Application for a Development Consent Order for the M42 Junction 6 Improvement

Waterway: Grand Union Canal

Deadline 1 Response

Written Representation

Drawing Title  
**FIGURE 8.3 PROPOSED LANDSCAPE PLANTING SHEET 1 OF 3**

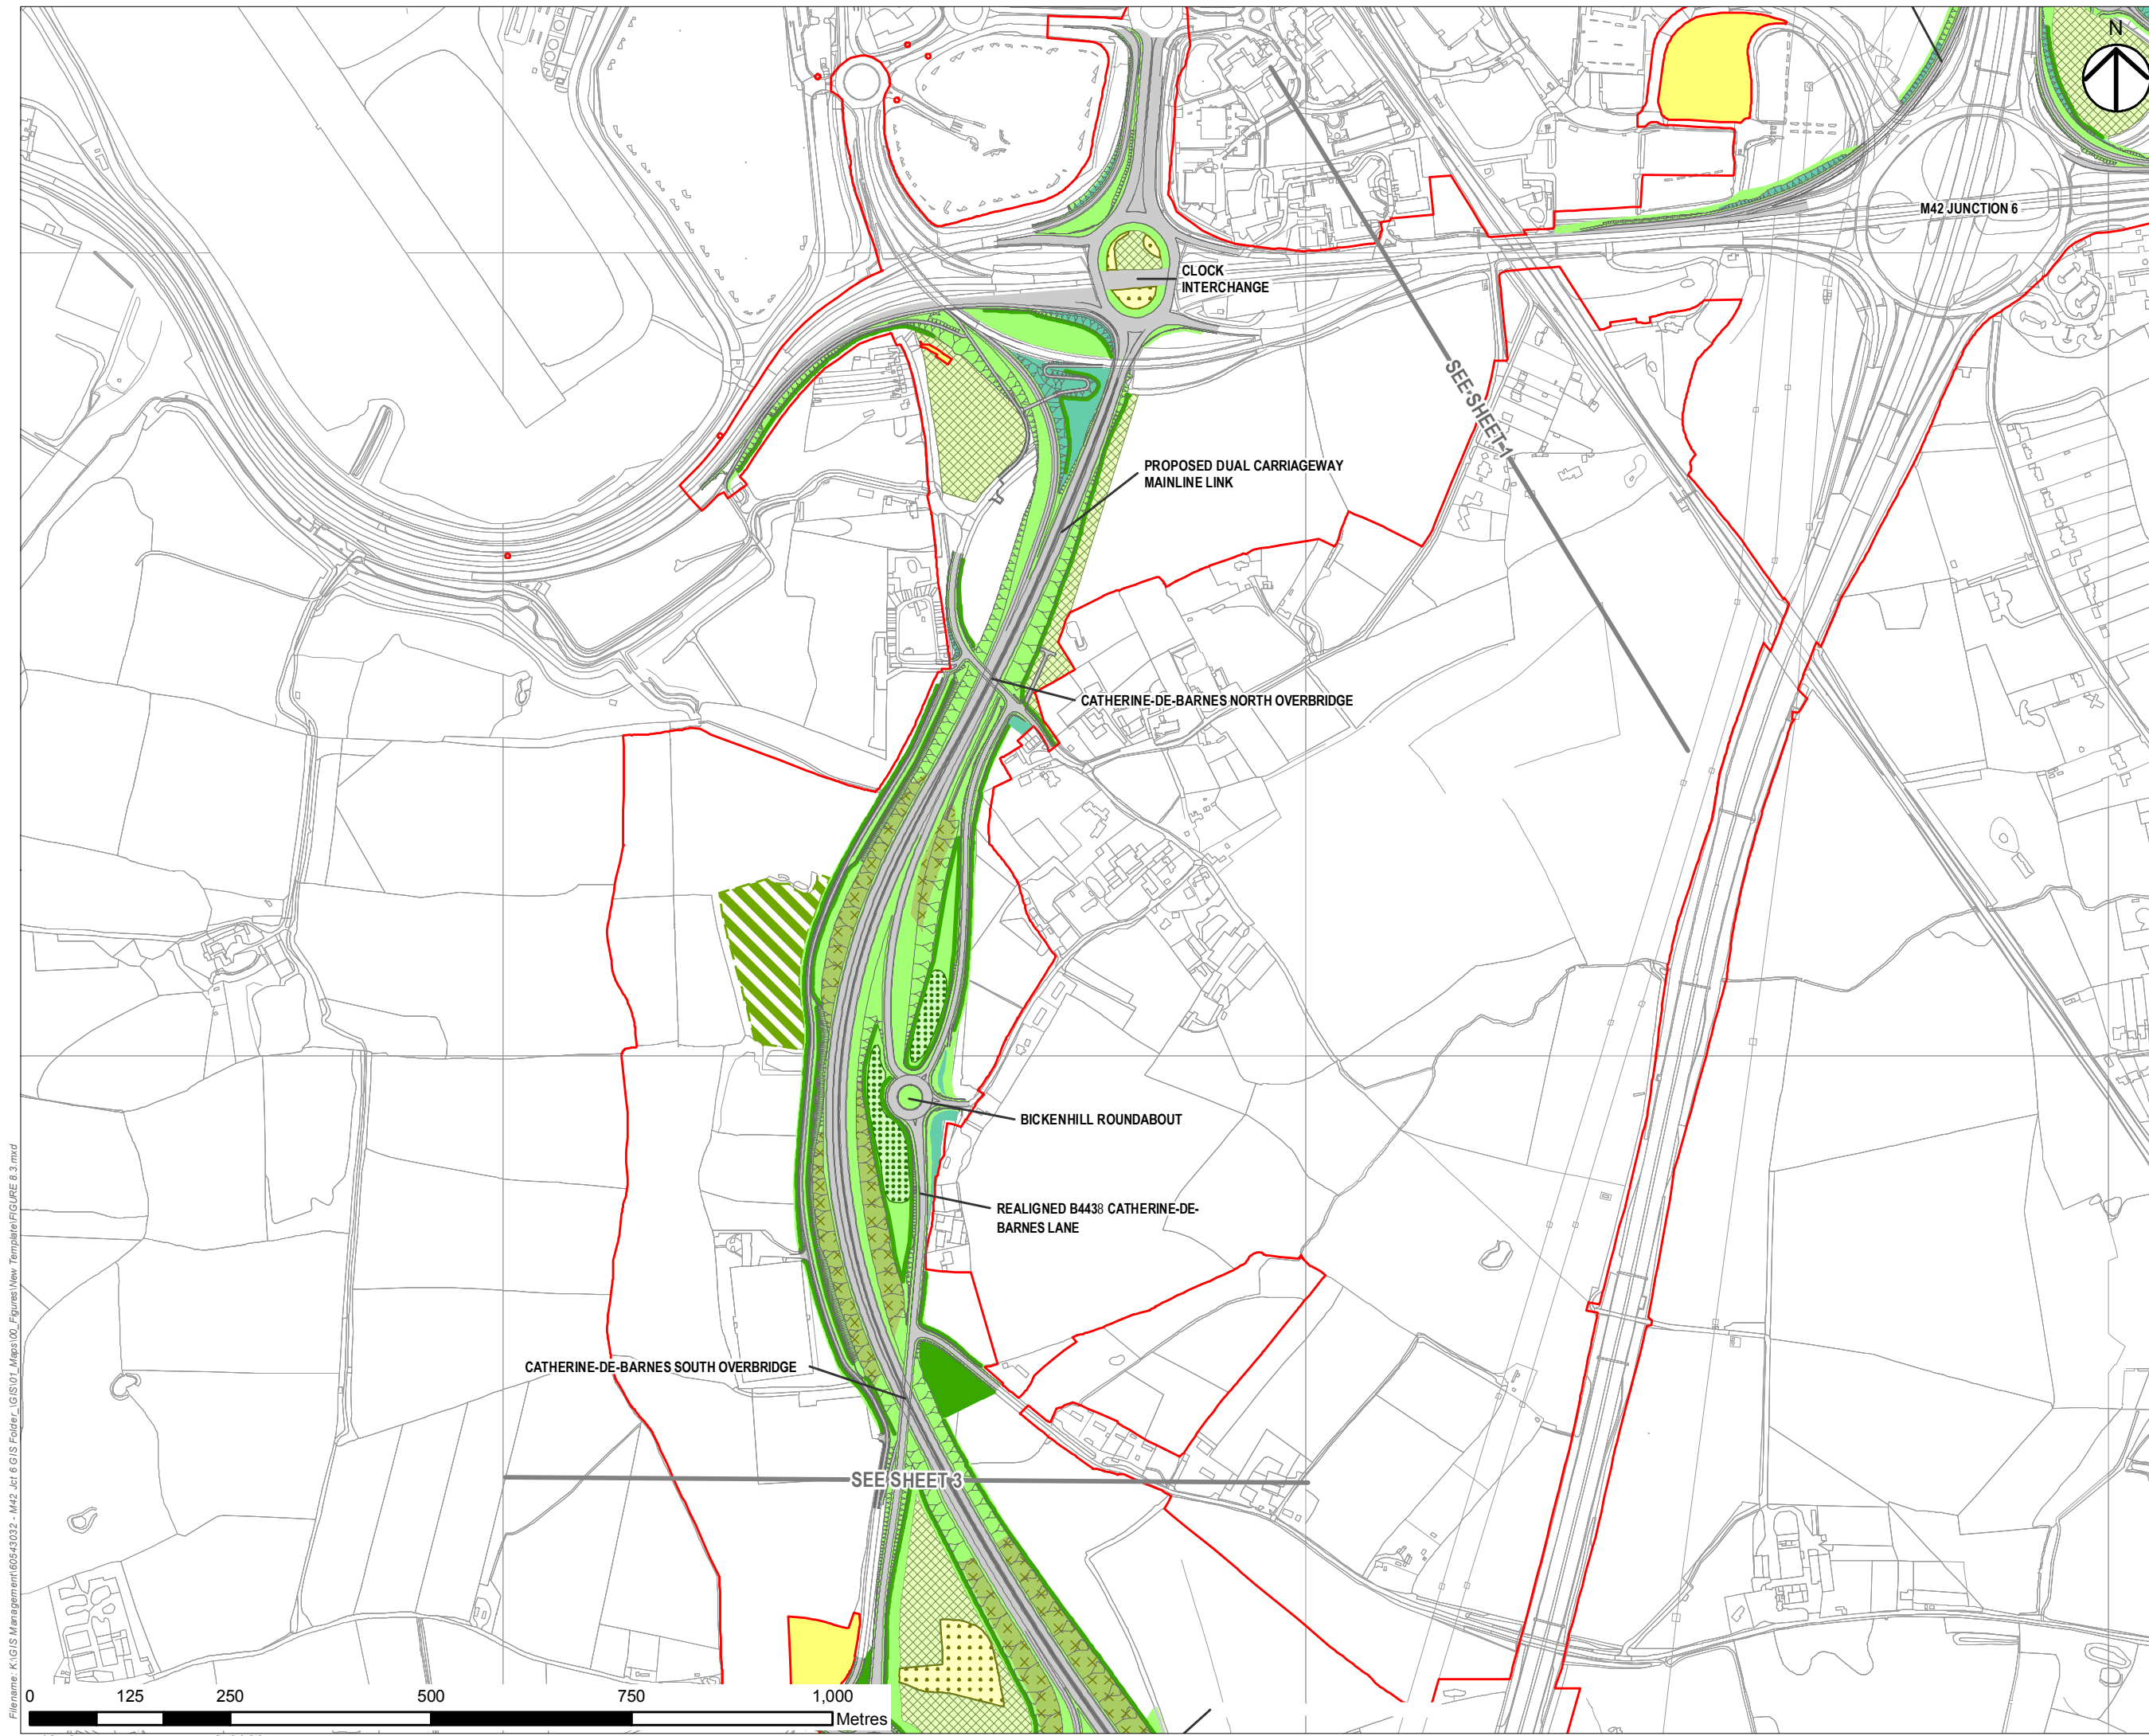
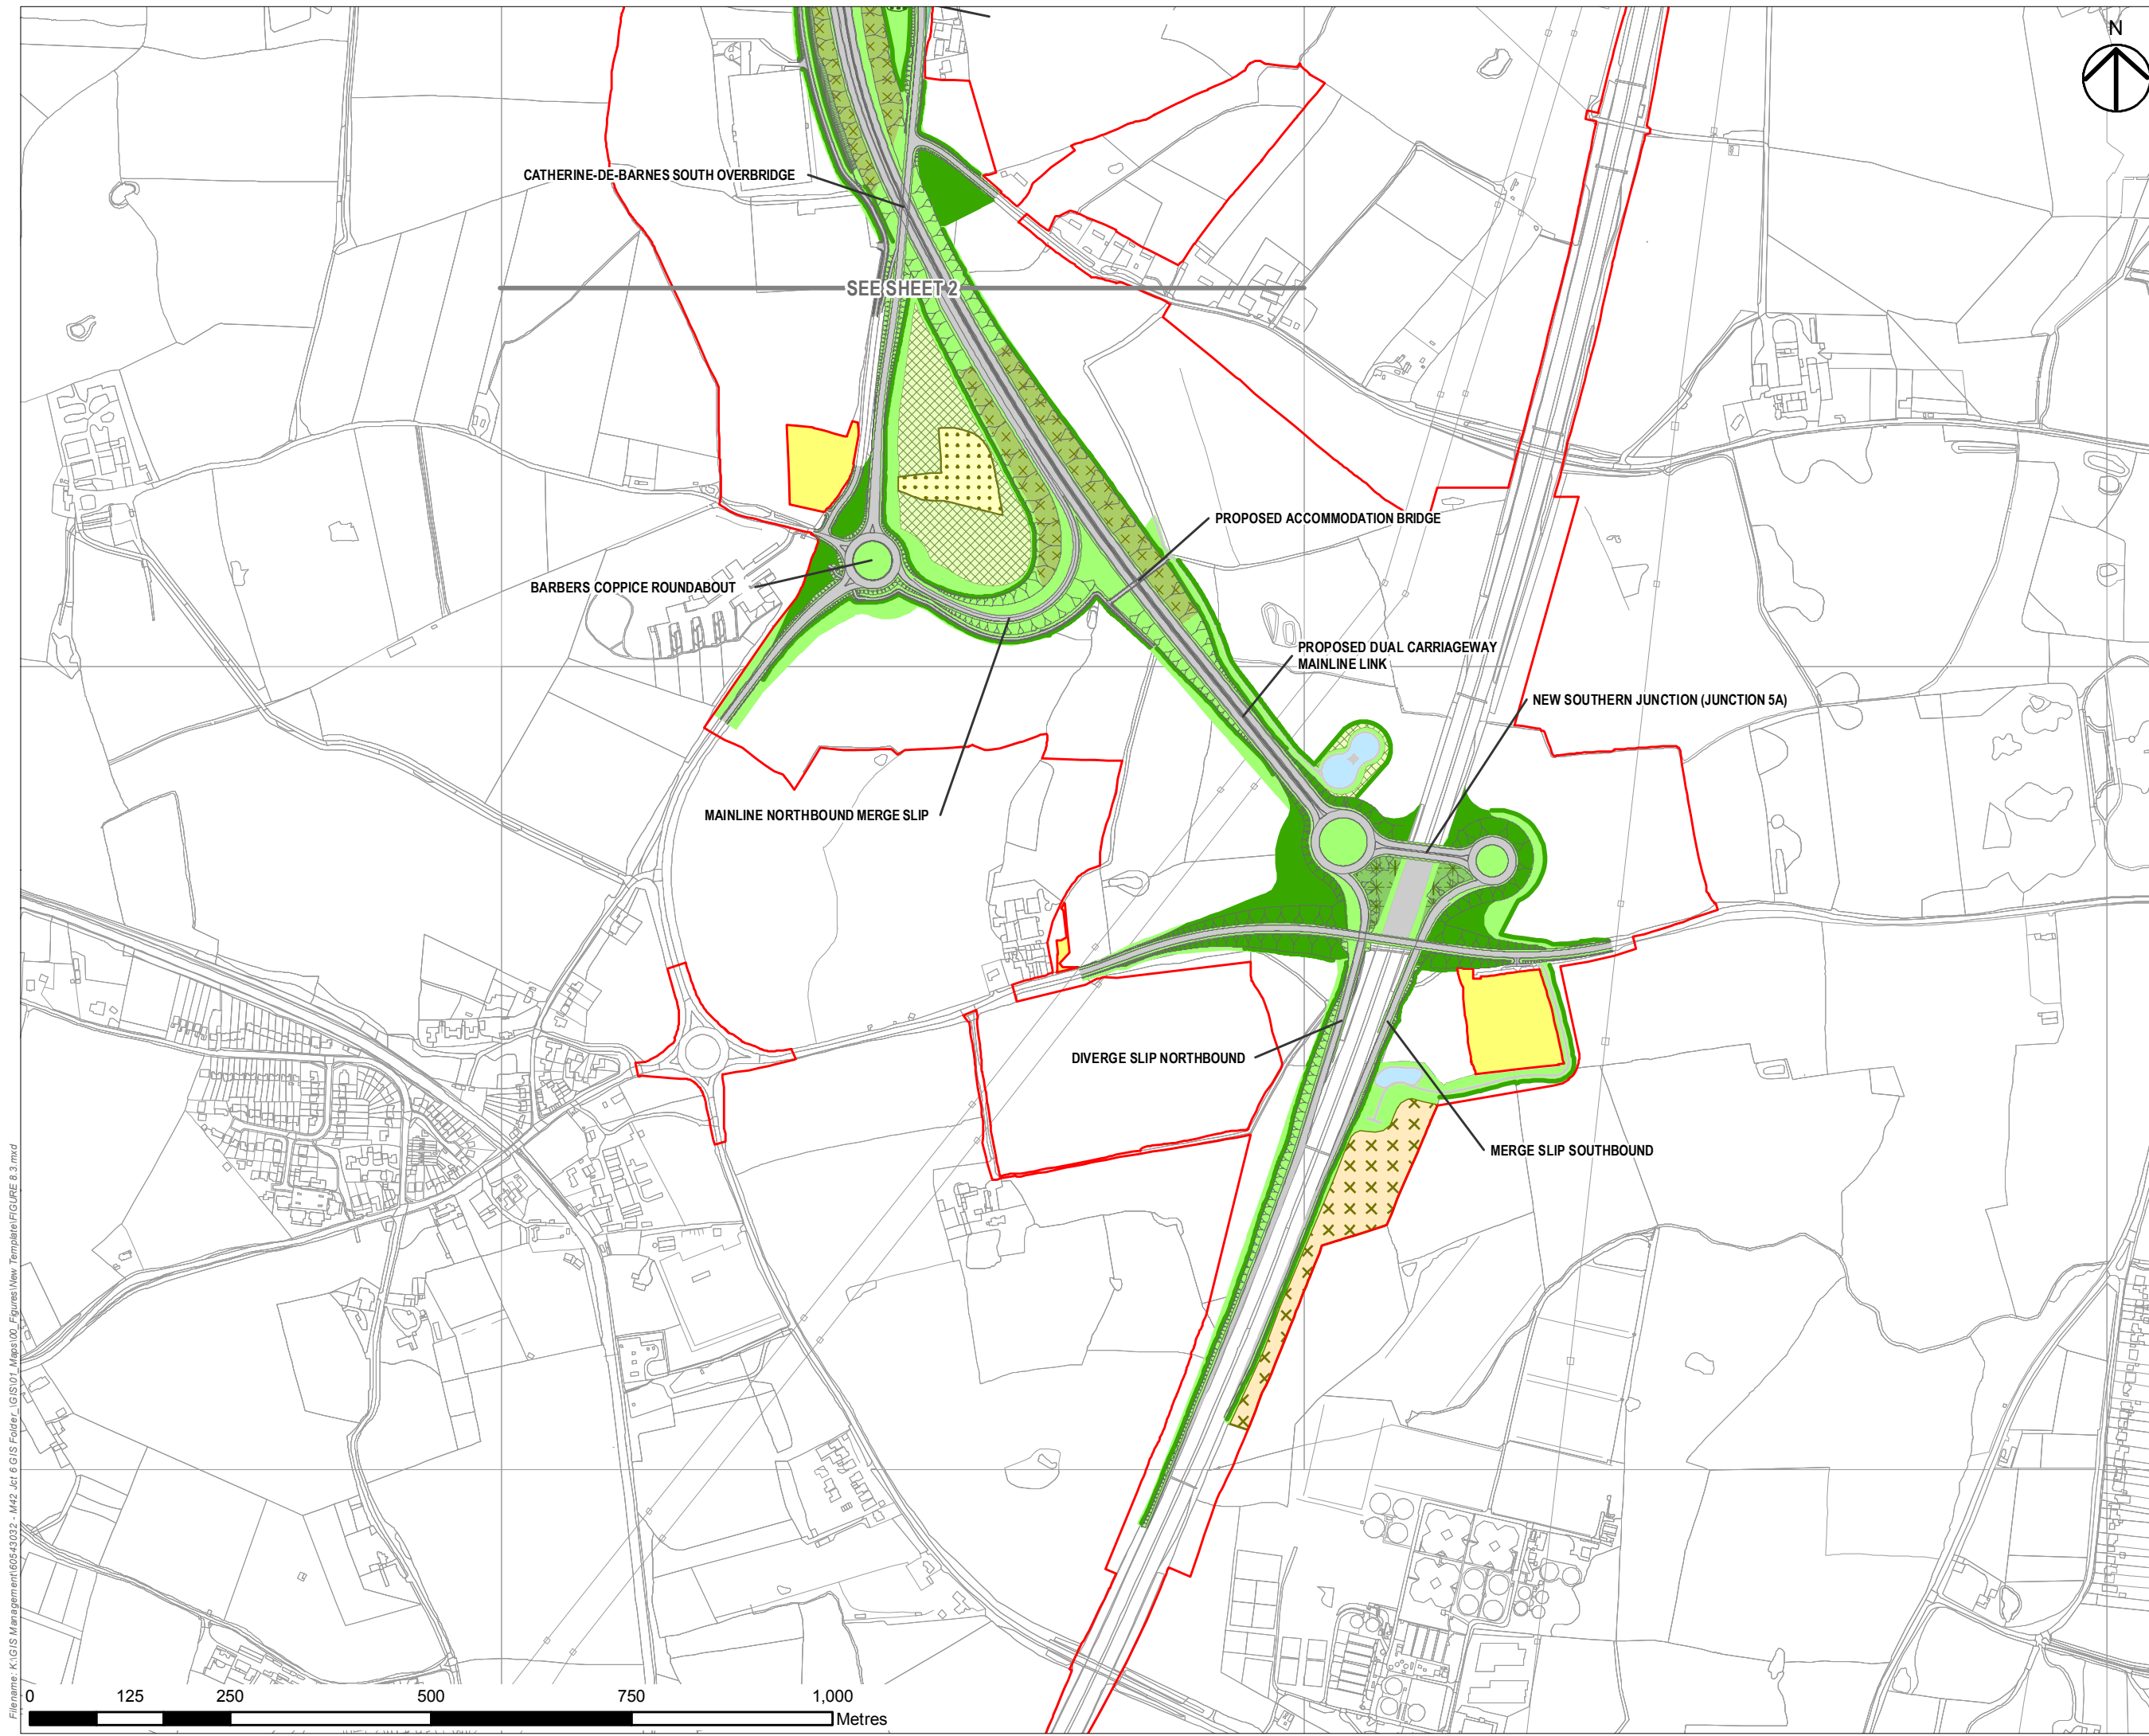
It is noted that the submission includes proposed landscaping adjacent to the junction works. We therefore consider that this natural screening is of importance to protect the views from the canal corridor and ask that these be delivered as early on as possible in order that they grow to provide an appropriate level of screening as soon as possible, for both visual and noise protection, to minimise the visual impacts of the proposal on canal users.
